Date: 09 January 2026
Our ref: 534905
Your ref: 2382/APP/2023/2906

Planning consultation: Amendment: Redevelopment of Site to create the Hillingdon Water sports Facility & Activity Centre and other associated works.

Location: Broadwater Lake, Moorhall Road, Harefield

SUMMARY OF NATURAL ENGLAND'S ADVICE

The use of drawings by the Customer acts as an agreement to the following statements. The Customer must not use the drawings if it does not agree with any of the following statements:

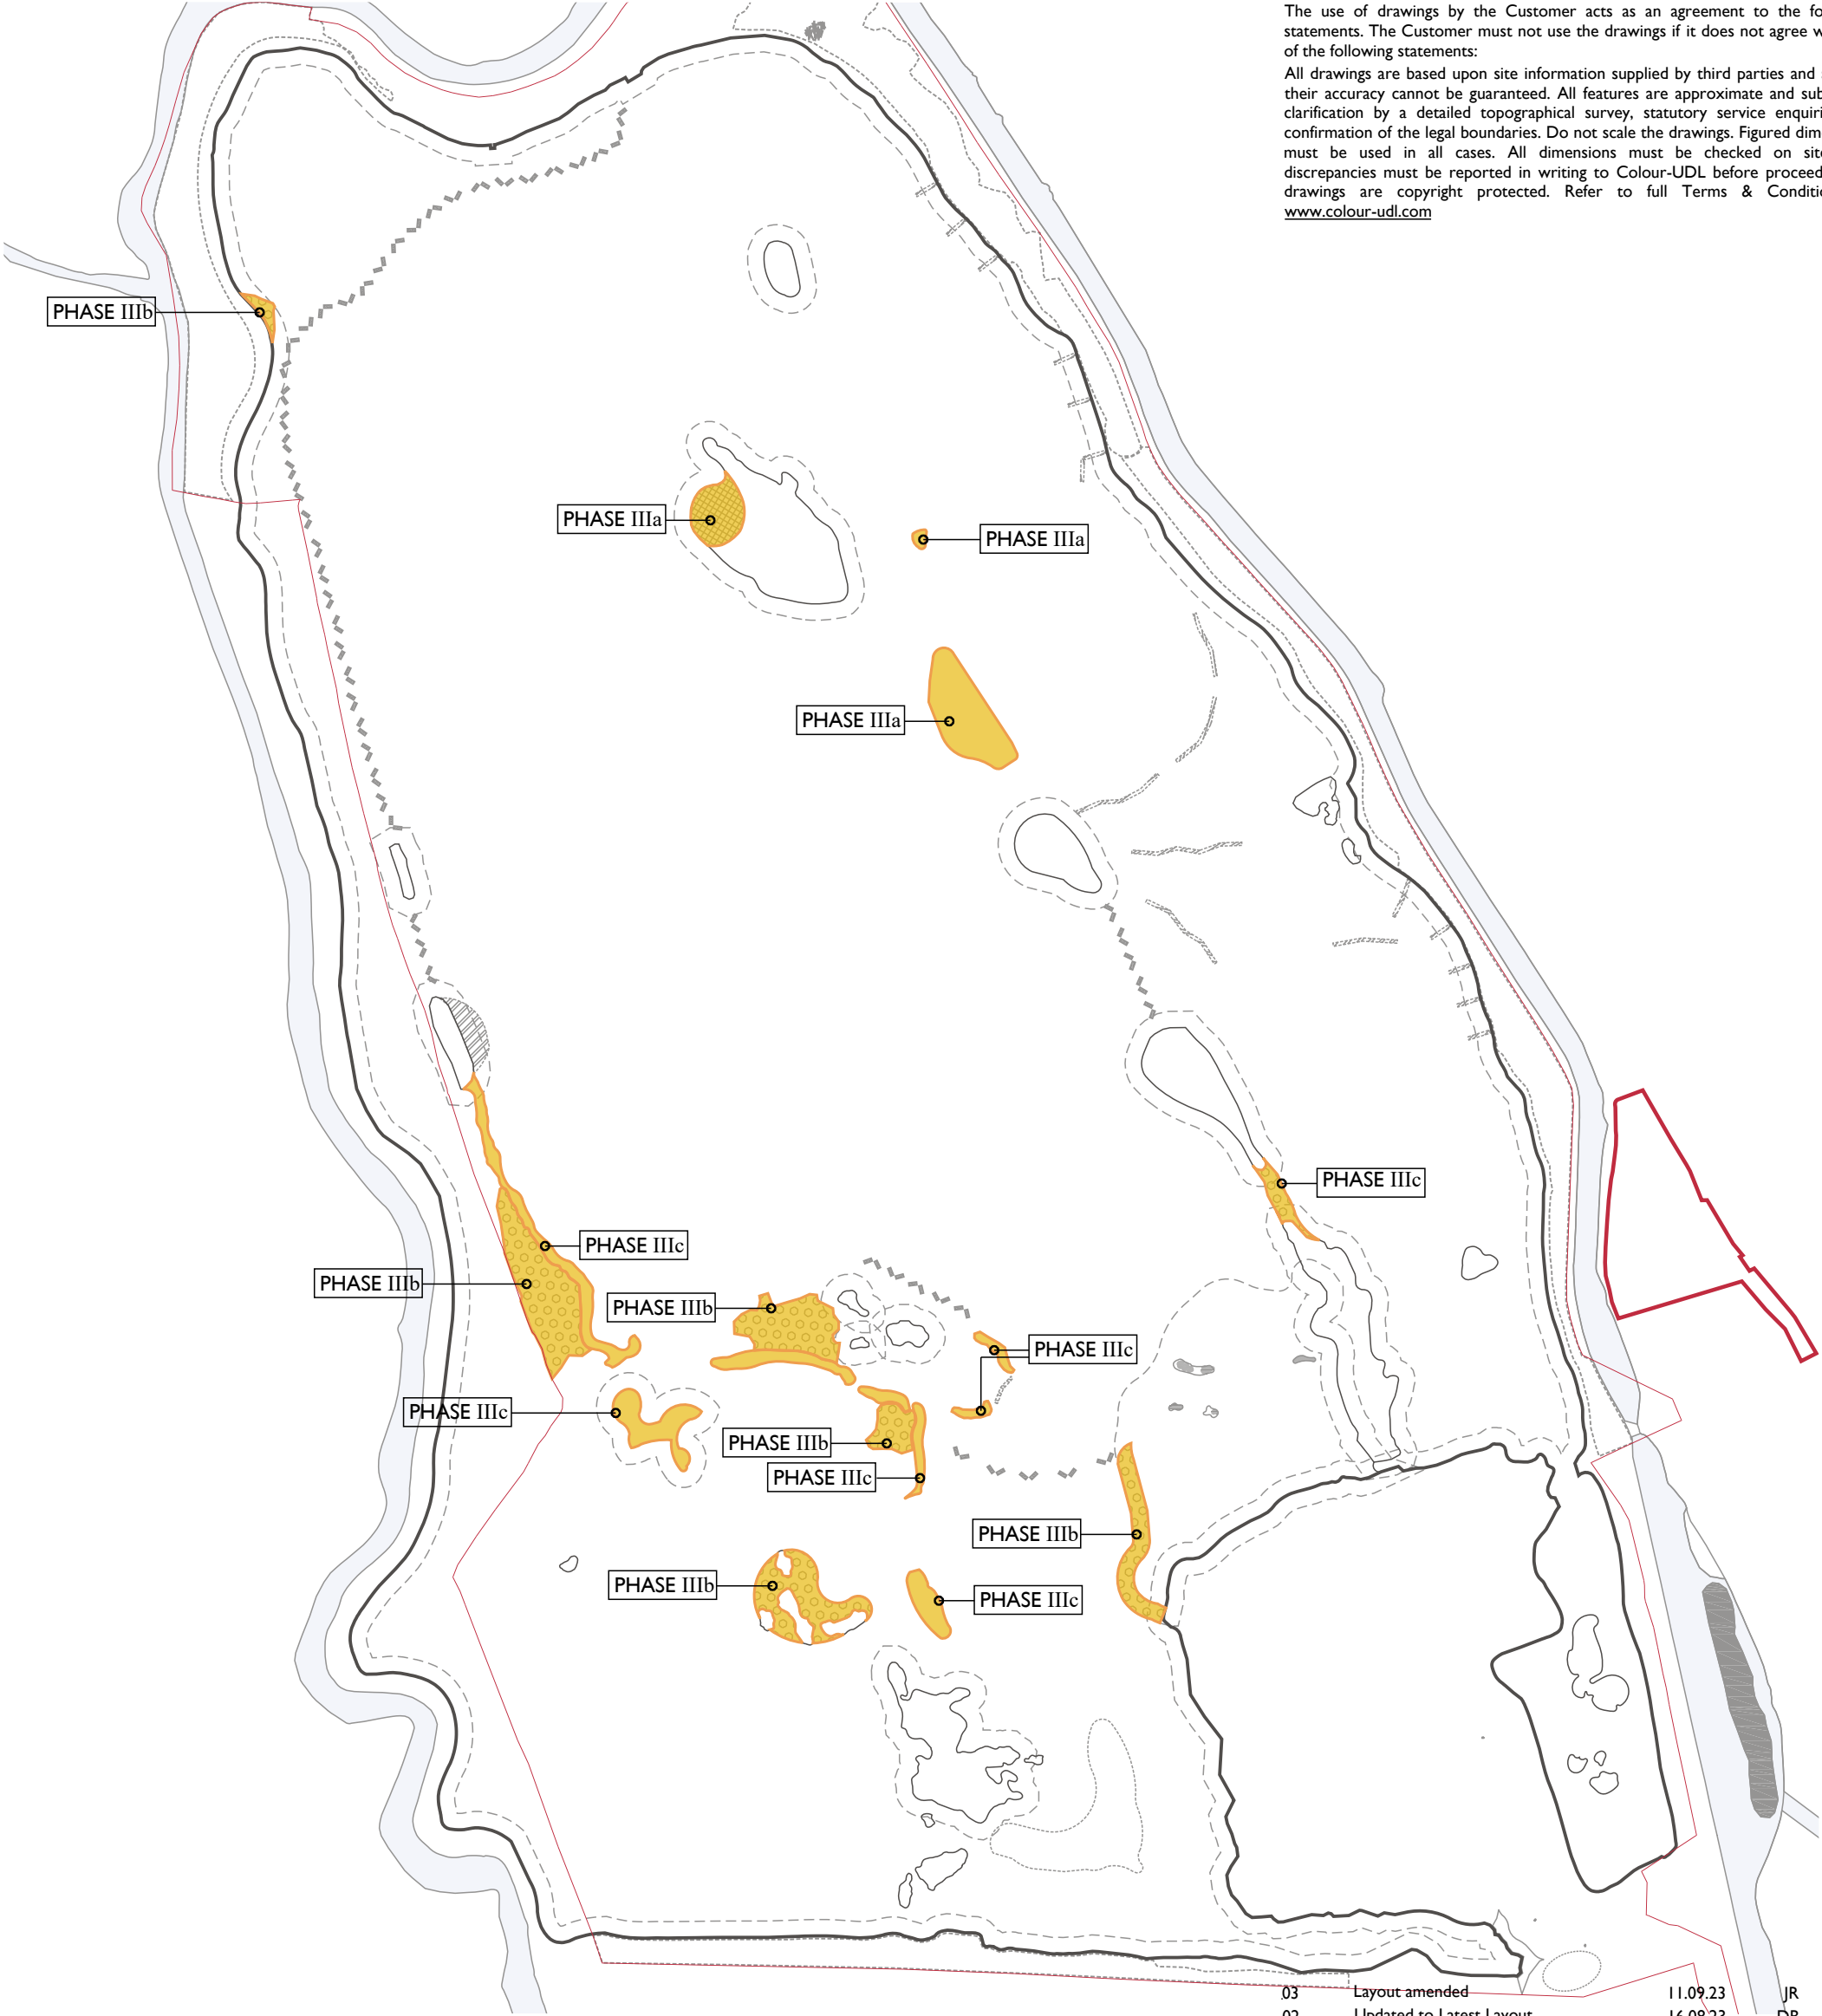
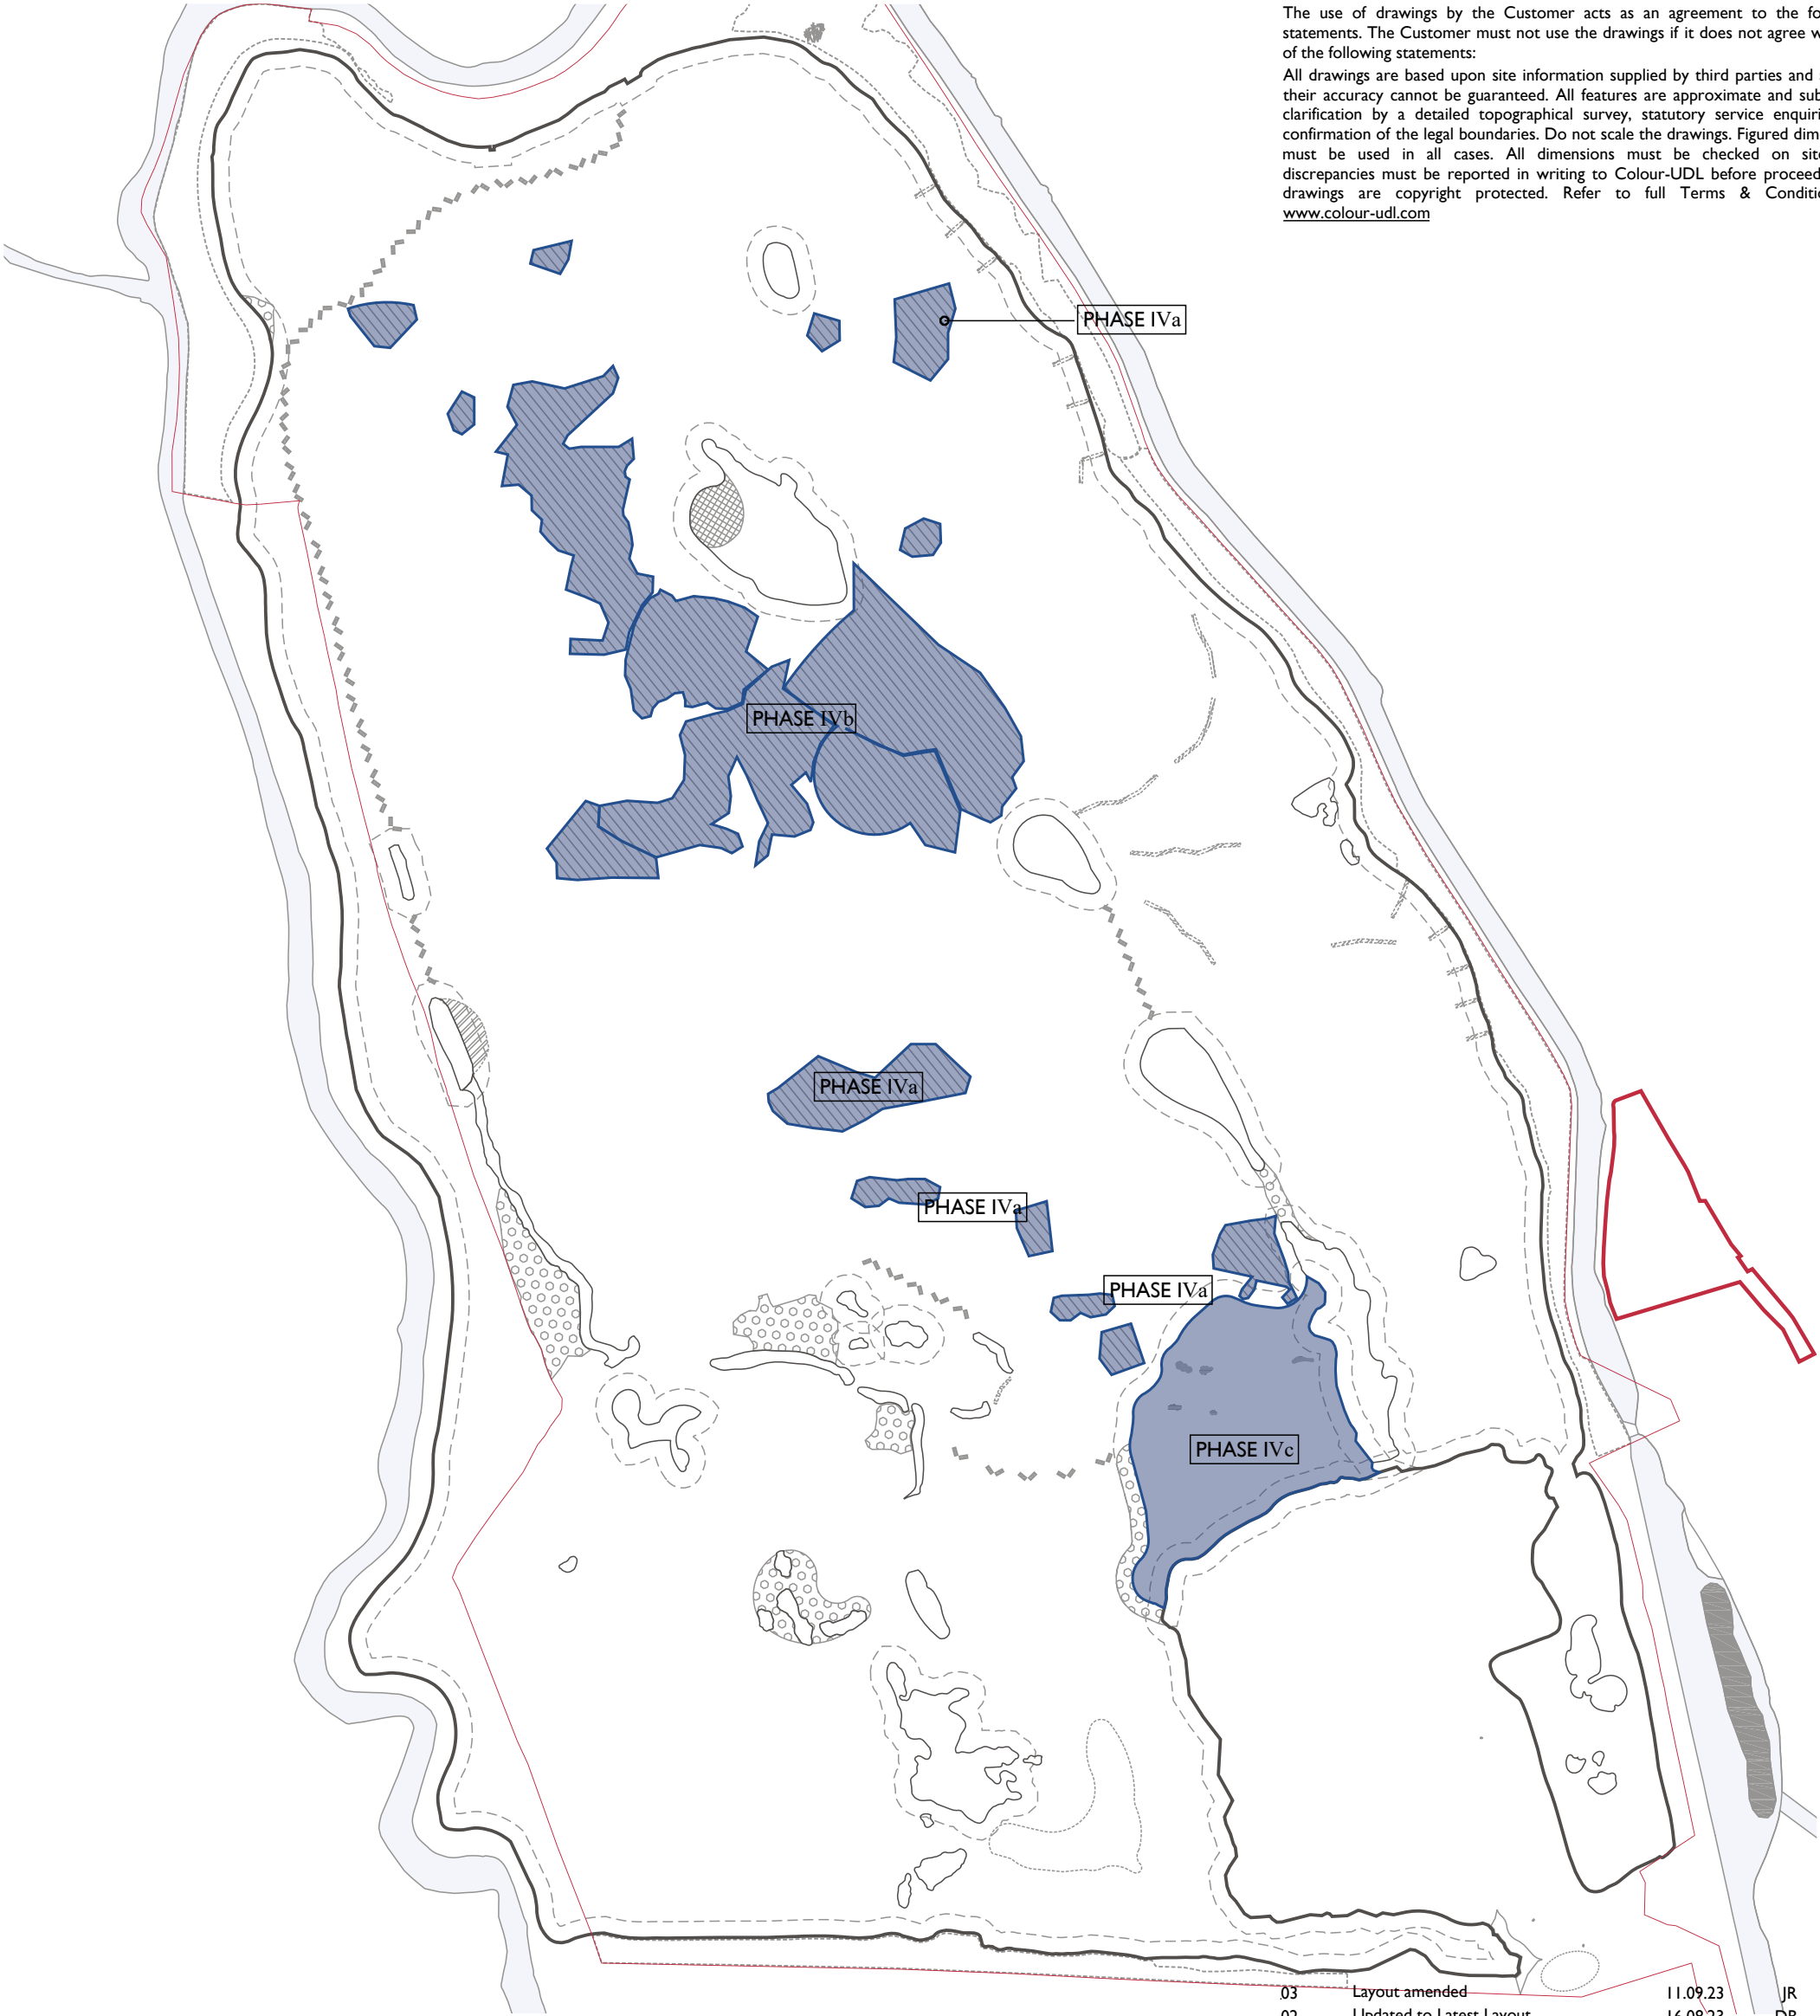
We apologise that we hadn't previously noted the importance of the site during the late summer months for the over wintering birds. We have reviewed the WeBS data for the site for the last three years and noted that in some years August and September have peak numbers of tufted ducks (*Aythya fuligula*). This information re-enforces the importance of the year-round refuge area on the lake, and the need to ensure that there is a refuge area during both construction and operation.

While Natural England view the refuge area as suitable mitigation to minimise impacts to moulting tufted duck numbers during operation, we would advise that construction schedules should be adjusted to take account of this. While we have previously advised that September is the best month for noisier construction activities, we now advise that these activities (such as demolition and piling) should take place during October – December. While these are still sensitive months and mitigation will be needed, this avoids the breeding and moulting season, and later winter months where it is likely to be colder with less food available for the wintering birds.
